STATE OF NORTH CAROLINA
DEPARTMENT OF TRANSPORTATION

Addendum No. 1

RE: Contract # C204315

1 SECTION OF US-401, 2 SECTIONS OF US-401 BUS, & 7 SECTIONS OF SECONDARY ROADS.

TYPICAL SECTION NO.1

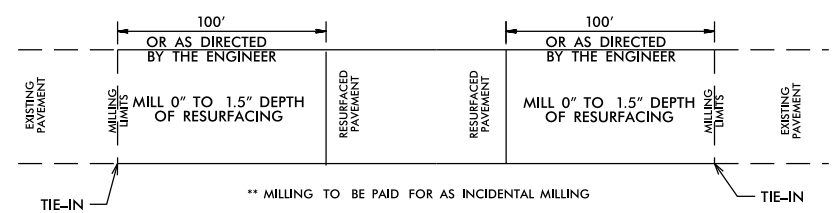
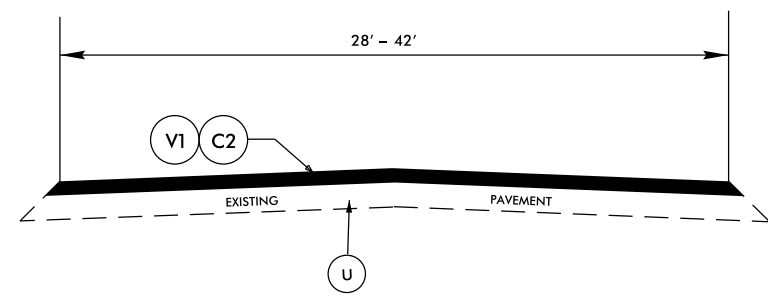
Sheet No.	Revisions
1	Removed Maps 2-4. These maps are no longer part of this project.
2	Removed Maps 2-4. These maps are no longer part of this project.
7	Revised Typical Section No.1 and Pavement Schedule. Latex Modified Microsurfacing has been eliminated.
11 and 12	Summary of Quantities revised to reflect elimination of Maps 2-4 and quantity changes listed below.
